# CITY OF ALBUQUERQUE

December 18, 2013

**Re: McDonald's Old Town MRP, 2305 Central Ave,  
Traffic Circulation Layout  
Engineer's Stamp dated 11-25-13 (J13-D053)**

McDonald's Old Town MRP
Variance Option 1
Rec'd. 12/31/13

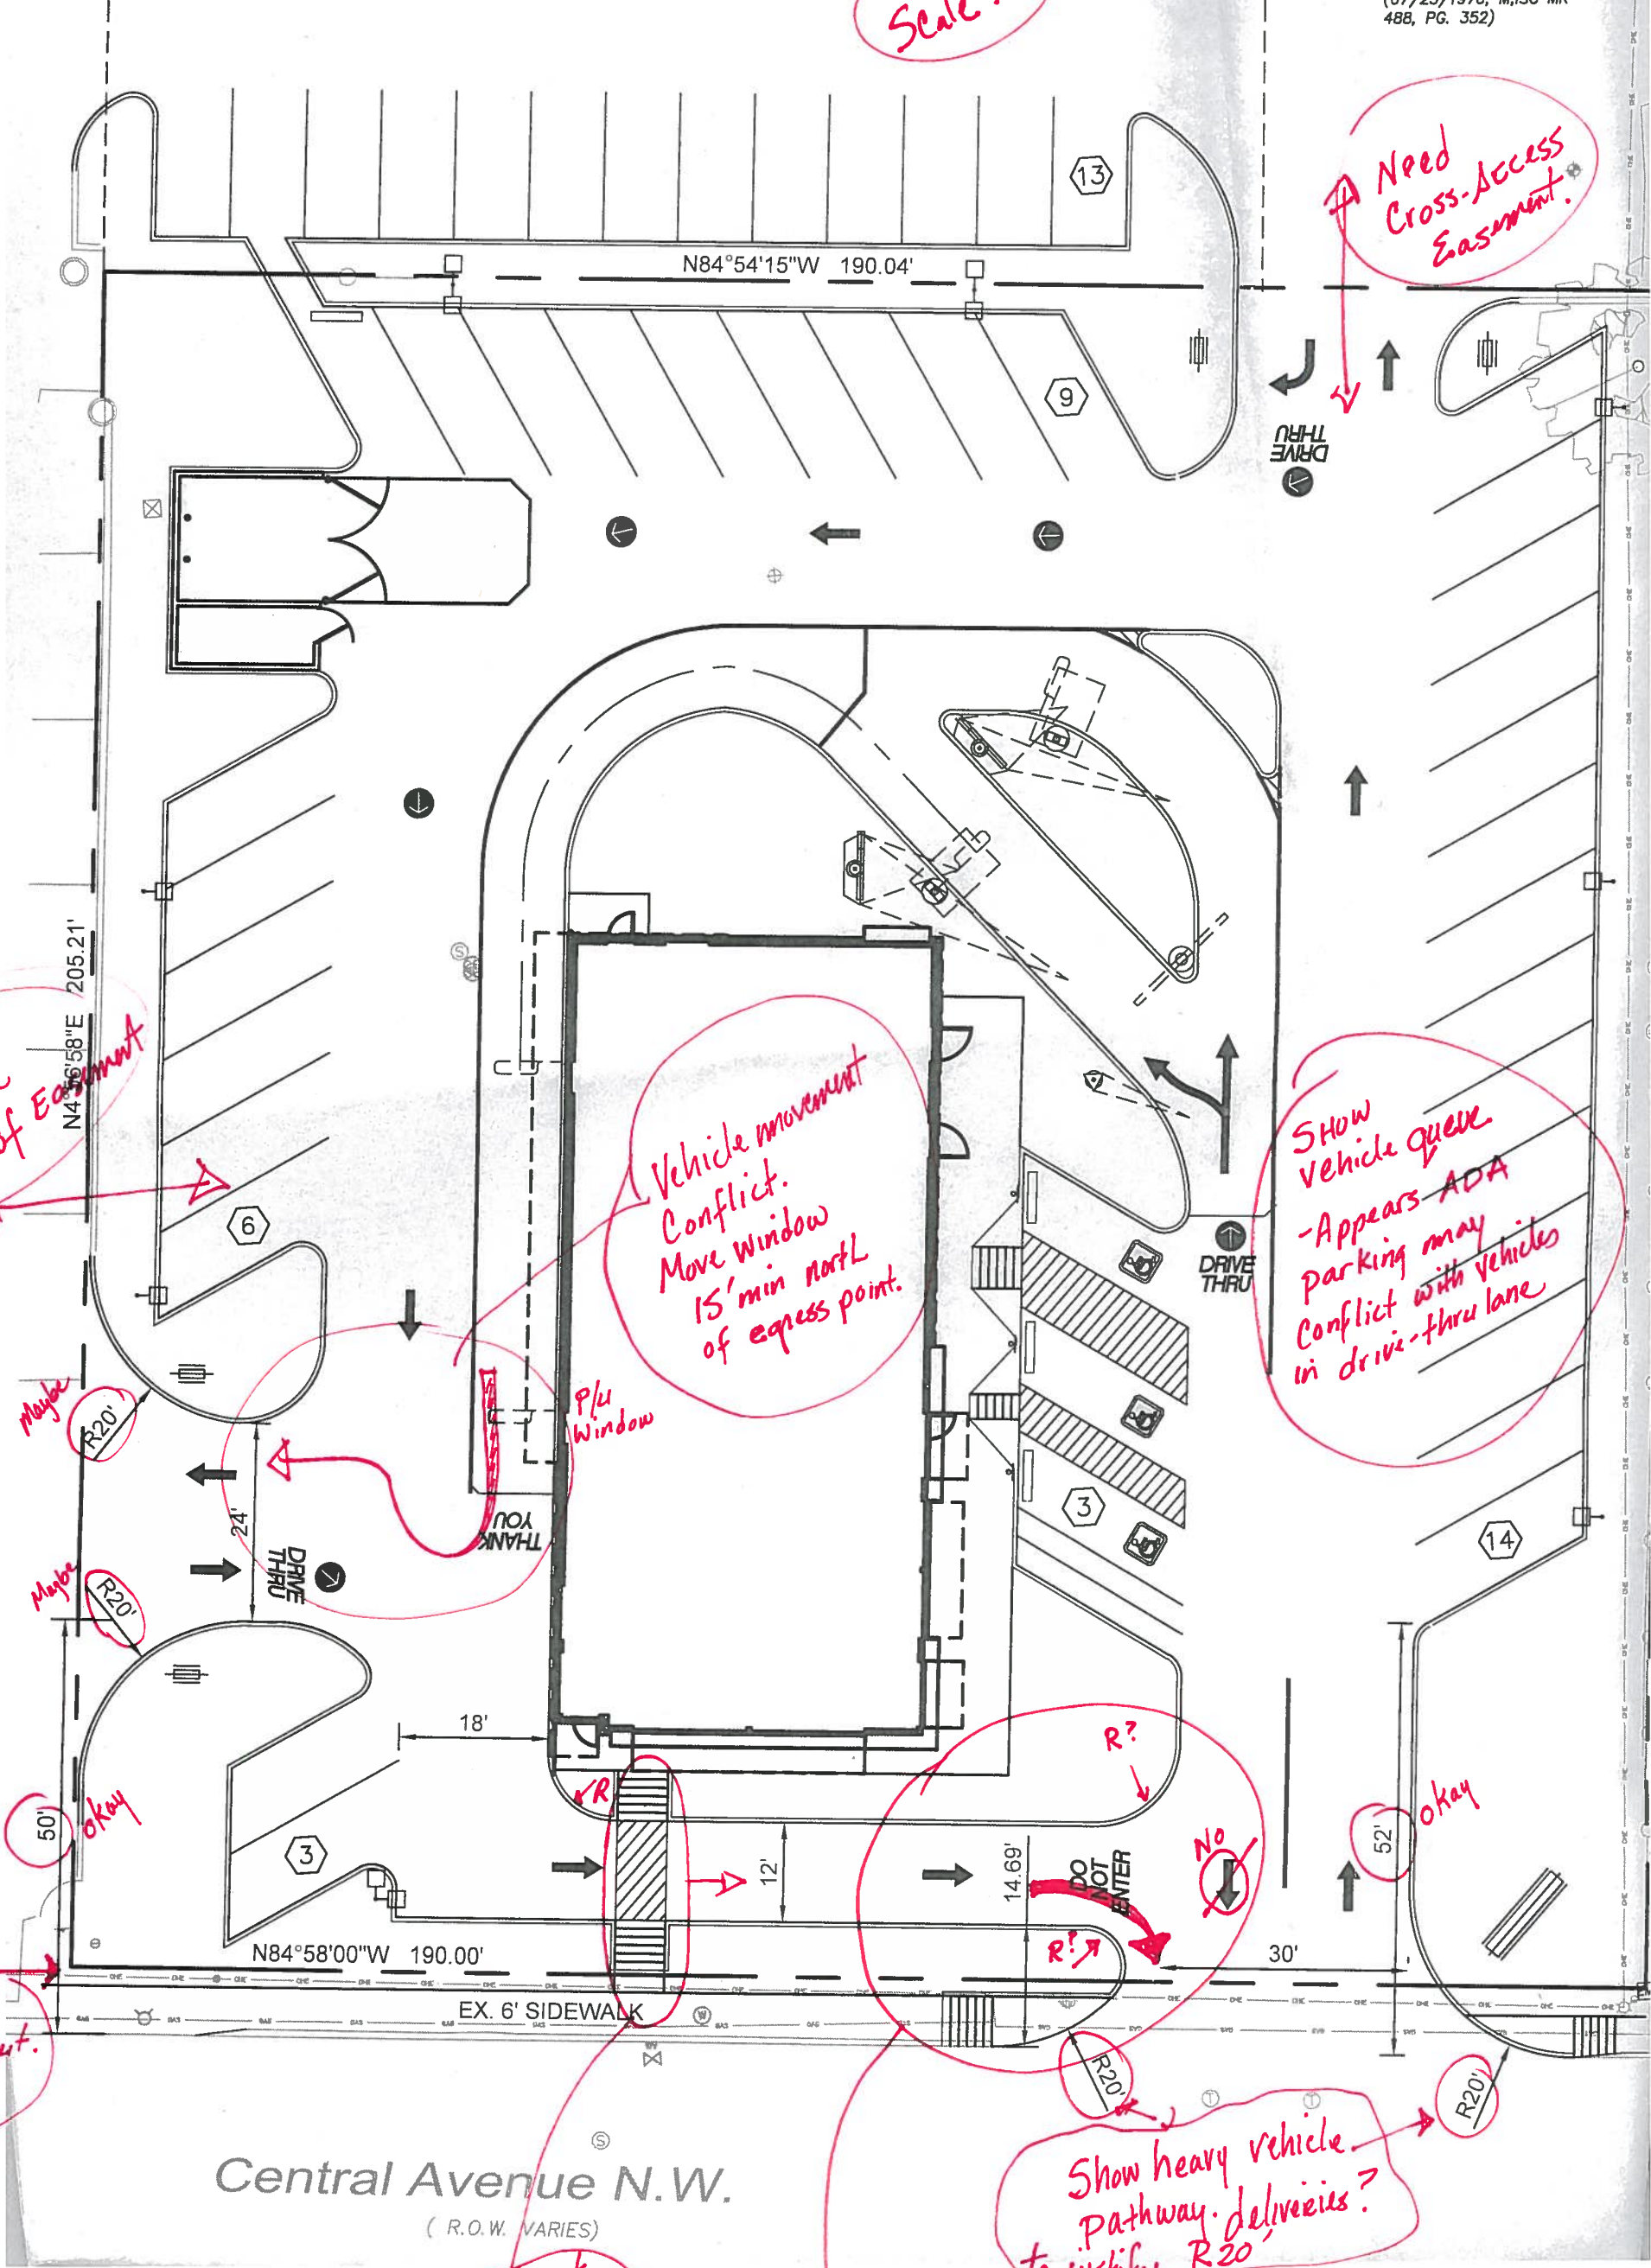
5. Relationship between site plan and keyed notes are full of errors.
6. A minimum of 100 foot throat lengths at access points from Central Ave. are required (see *Development Process Manual (DPM)*, Chapter 23, Section 7, Table 23.7.1). The proposed lot entrance from the western access (existing private access easement) to the drive-thru lane appears to be less than 20 feet. The eastern access has parking stalls that back into the required clear path of the 100 feet throat depth. Please revise layout.

7. Per the *DPM*, a 6 ft. wide *ADA* accessible pedestrian pathway is required from the public sidewalk to the building entrances. Please clearly show this pathway and provide details.

8. List the width all proposed turnouts.
9. Since Central Ave. is an arterial roadway, driveways with right-in / right-out-only have a minimum driveway width of 30 feet, and 36 feet minimum with left-turn access (see the *DPM*, Chapter 23, Section 6, Part B.8.a).

10. Show a detail of the wheelchair ramps located at the proposed driveway, or refer to the appropriate city standard.
11. Please show the location of the nearest driveway on the abutting eastern lot and existing infrastructure (curb, sidewalk, ramps). Show how proposed infrastructure is tied to the existing.

12. Proposed curb return requires a minimum curb radius of 25 feet (see the *DPM*, Chapter 23, Section 6, Part B.9.a). *City of Albuquerque(COA)*

13. The western drive access on Central warrants pavement striping due to its width and median access. Refer to *DPM* Chapter 23, Section 6, Part B.10.

14. The proposed infrastructure changes to the western drive access are outside of the property lines of this development. Is there an agreement with abutting property to work within their property and ROW frontage?

17. Abandon curb cuts must be replaced with sidewalk and curb & gutter. A build note must be provided referring to the appropriate *COA* standard drawings #2430 and #2415.

18. List radii for all curves shown; for passenger vehicles, the minimum end island radius is 15 feet, and 25 feet minimum on inside edge of drive aisles.

19. Drive-thru lane widths are a minimum 12 feet with a 25 foot minimum radius (inside edge) for all turns. A 15 foot radius can be used with an increase in lane width to 14 feet (see the *DPM*, Chapter 23, Section 6, Part B.7.E).

20. One-way vehicular paths require pavement directional signage and a posted "Do Not Enter" sign at the point(s) of egress.
21. The proposed motorcycle parking spaces require signage.
